Department of Community Services

Subject: Autumn Acres Sketch Plan – Preliminary Comments (SKP231)

Autumn Acres Sketch Plan Review

ZONING MAP

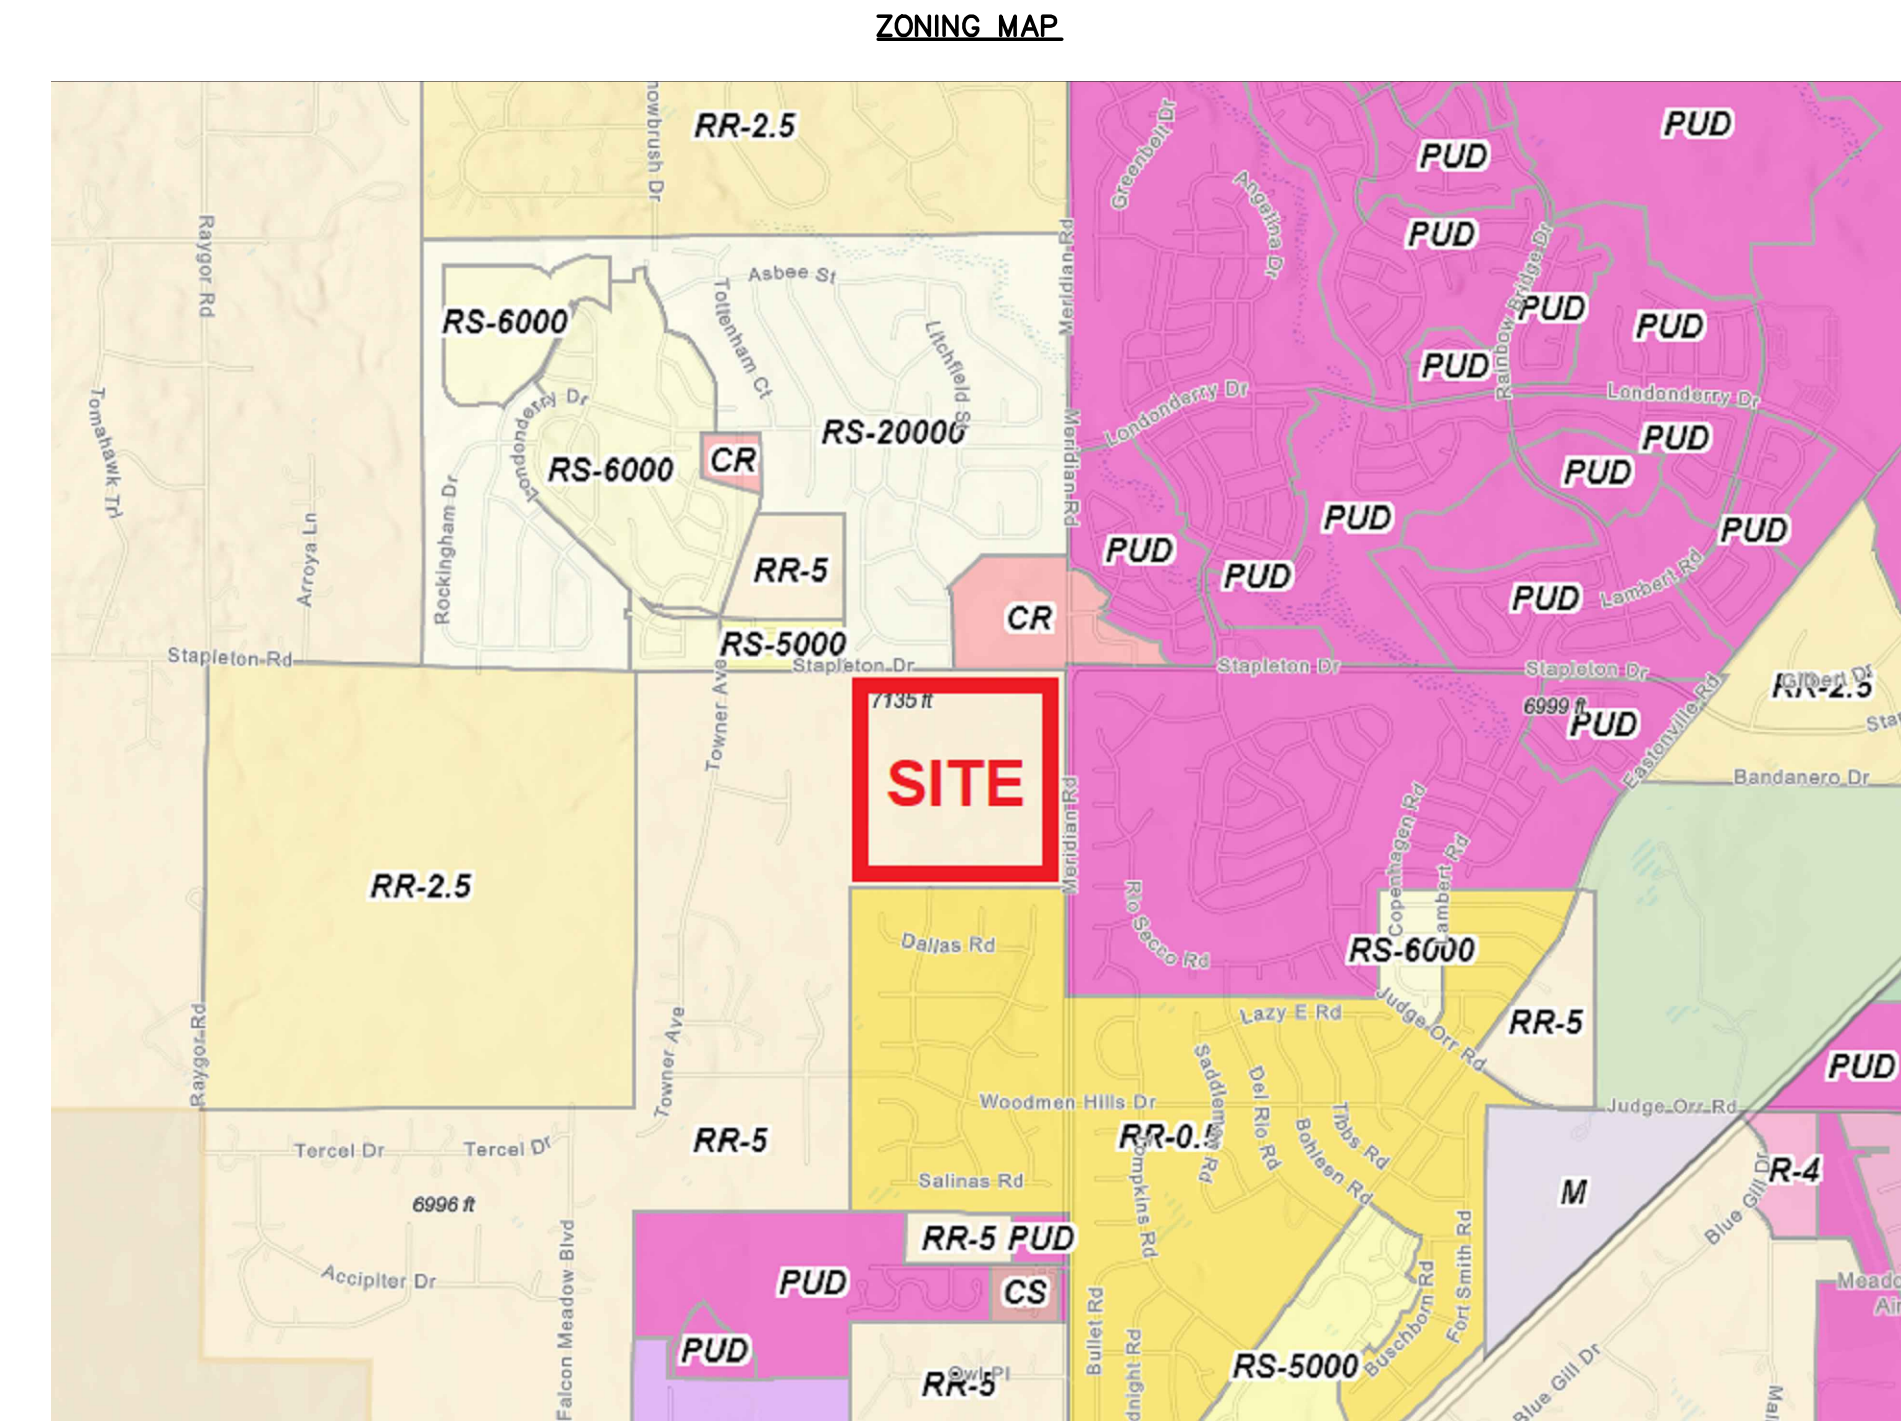
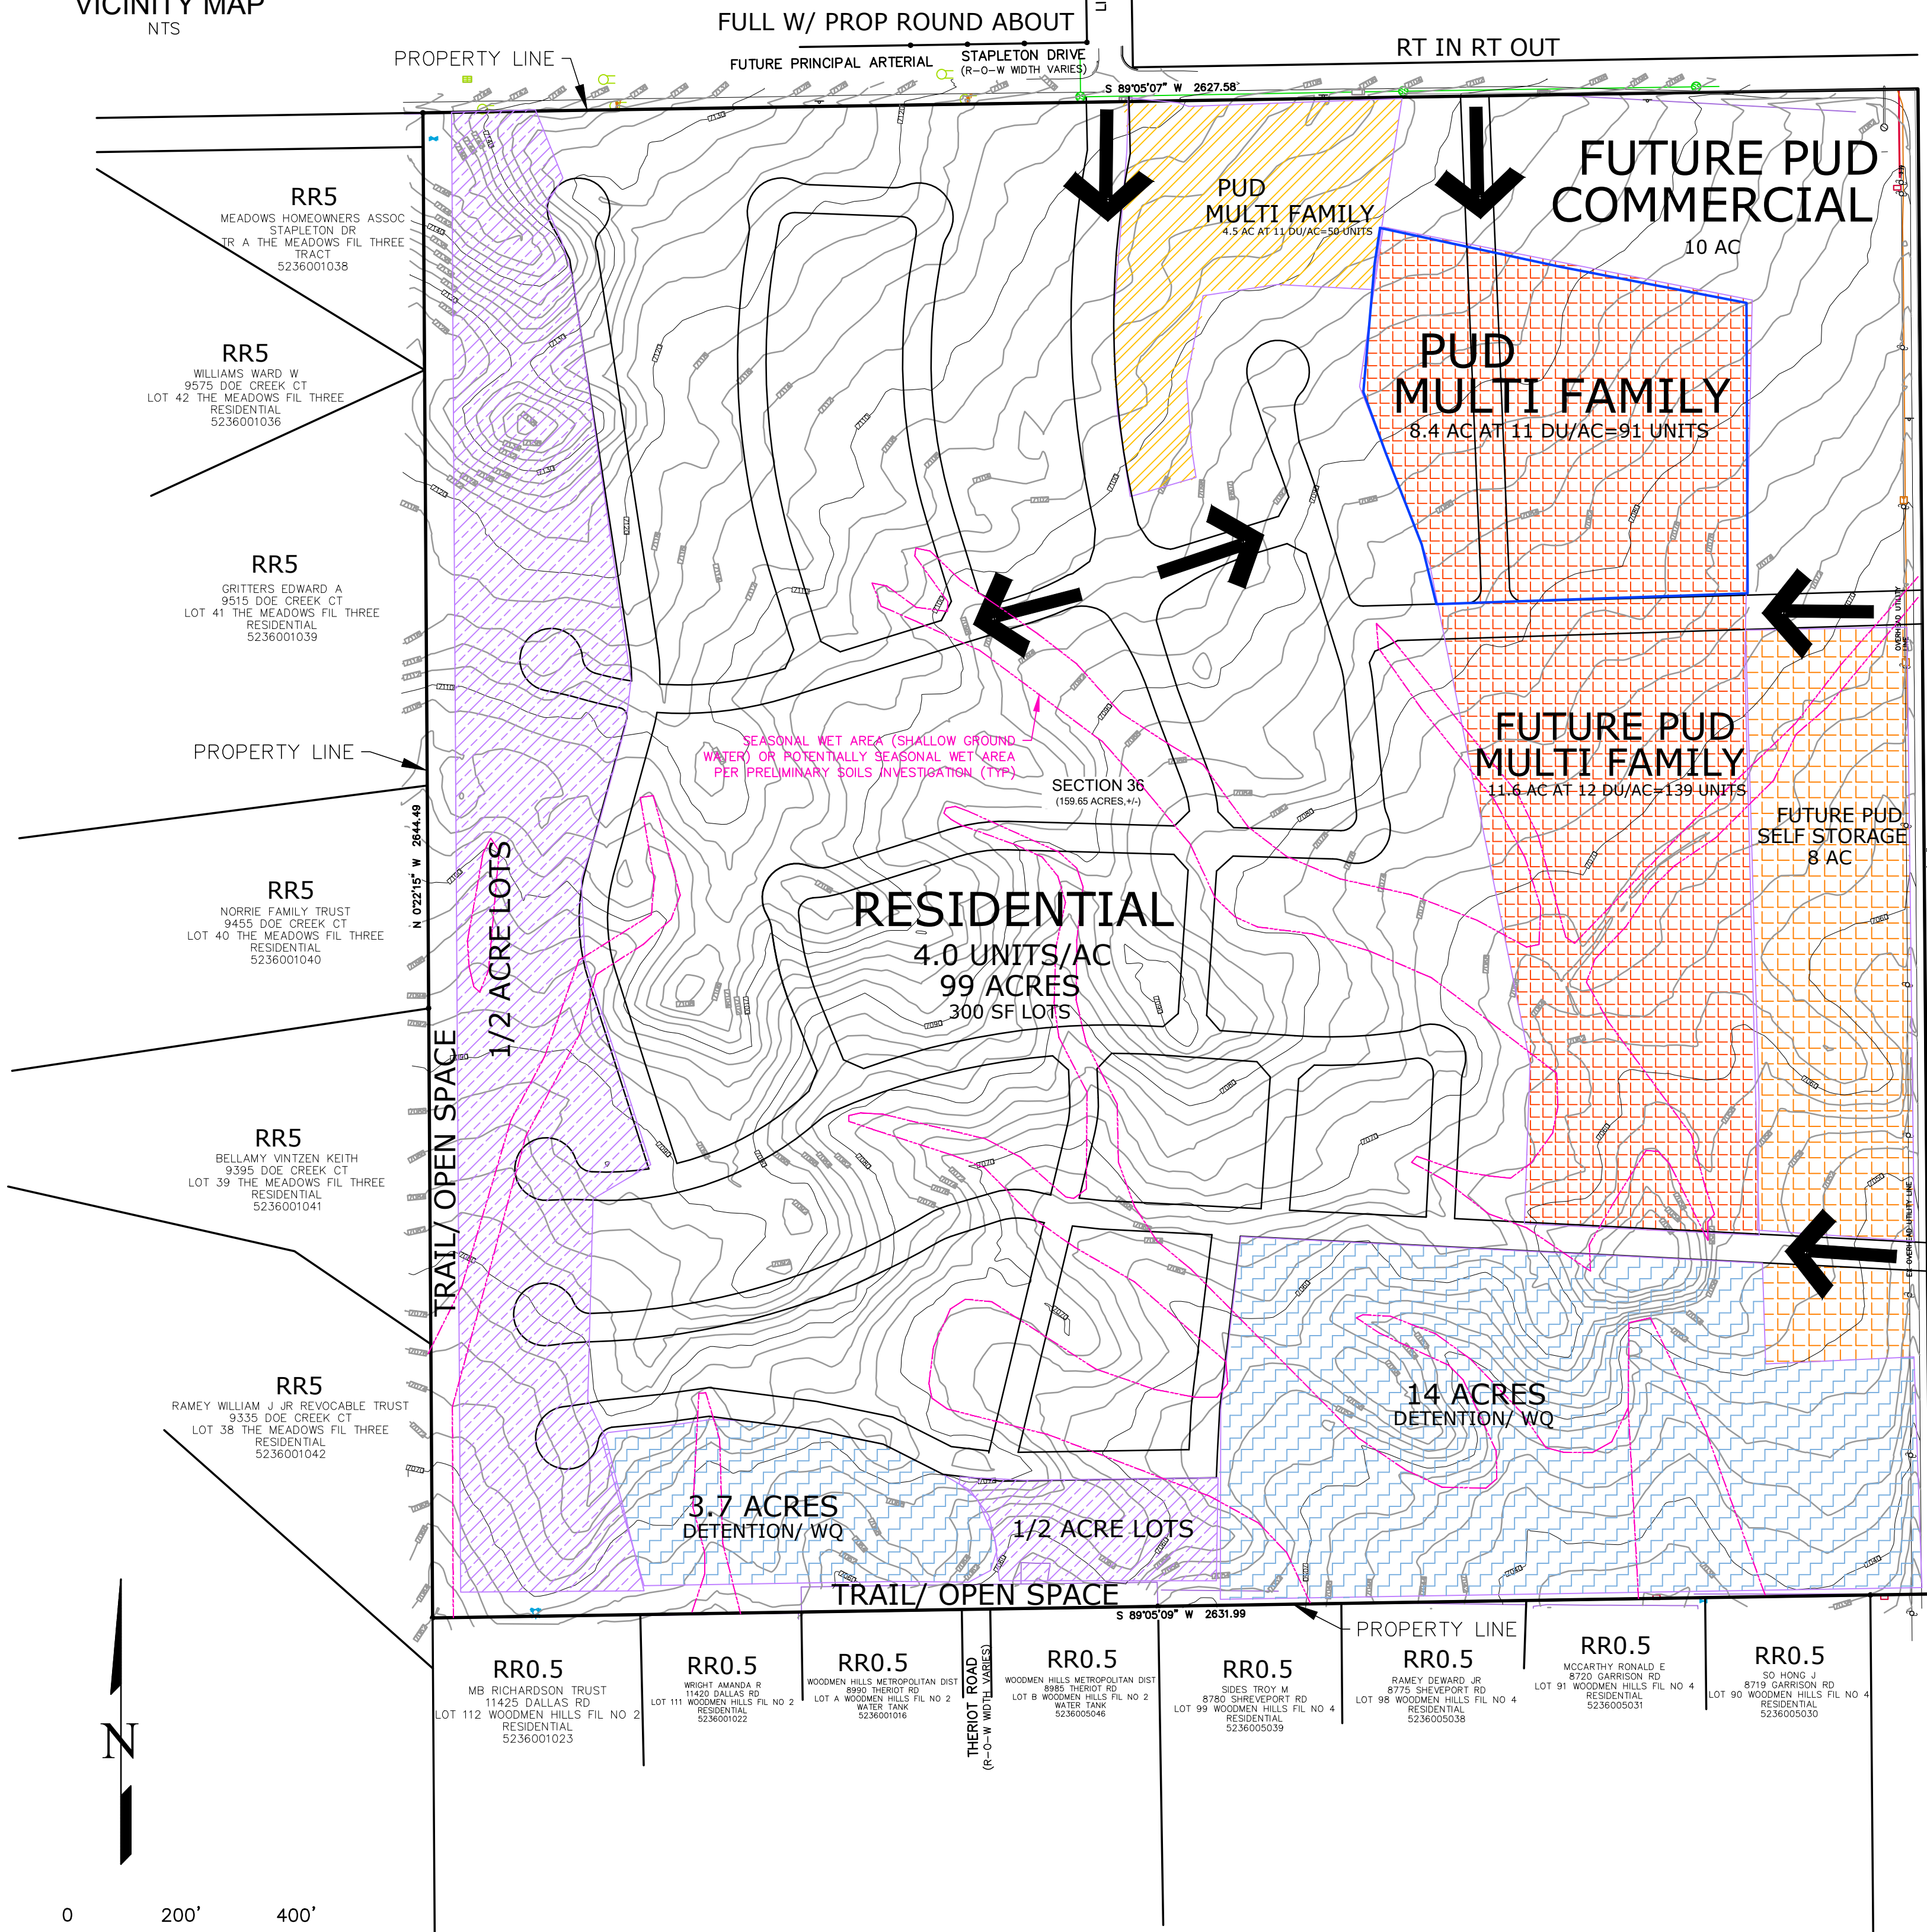
Approximately 18.5 acres of open space will be provided within the site. Open space and space trails are proposed along the west and south sides of the site. The applicant states that “additional open space may be provided with future submittals as more detailed design is completed and includes elements such as landscape buffers”.

The applicant is reminded that for Planned Unit Development zoning, the minimum open space dedication is 10% of the total site area which does not include storm water infrastructure. The Land Development Code Section also outlines that dedicated open space tracts be large, usable, and contiguous. The proposed narrow tracts of open space, while serving a buffer to adjacent development, do not provide a substantially beneficial to the denser areas of the site. Additionally, for a sketch plan application, the applicant should be providing sufficient detail on proposed land use allocations, to include open space dedications. Staff understands that there are minor refinements to final open space dedications due to site design considerations but is concerned they are referenced in the letter of intent as these small areas should not be the majority of the open space dedication.

The Park Advisory Board recommends that the Planning Commission and the Board of County Commissioners include the following conditions when considering and/or approving the Autumn Acres Sketch Plan: (1) provide a detailed land use table outlining open space areas and strongly encourage the applicant to locate open space tracts in usable and convenient areas as outlined in the Land Development Code (2) fees in lieu of land dedication for regional and urban park purposes will be calculated upon review of forthcoming preliminary plans and final plats, and will be required at time of the recording of the forthcoming final plats.
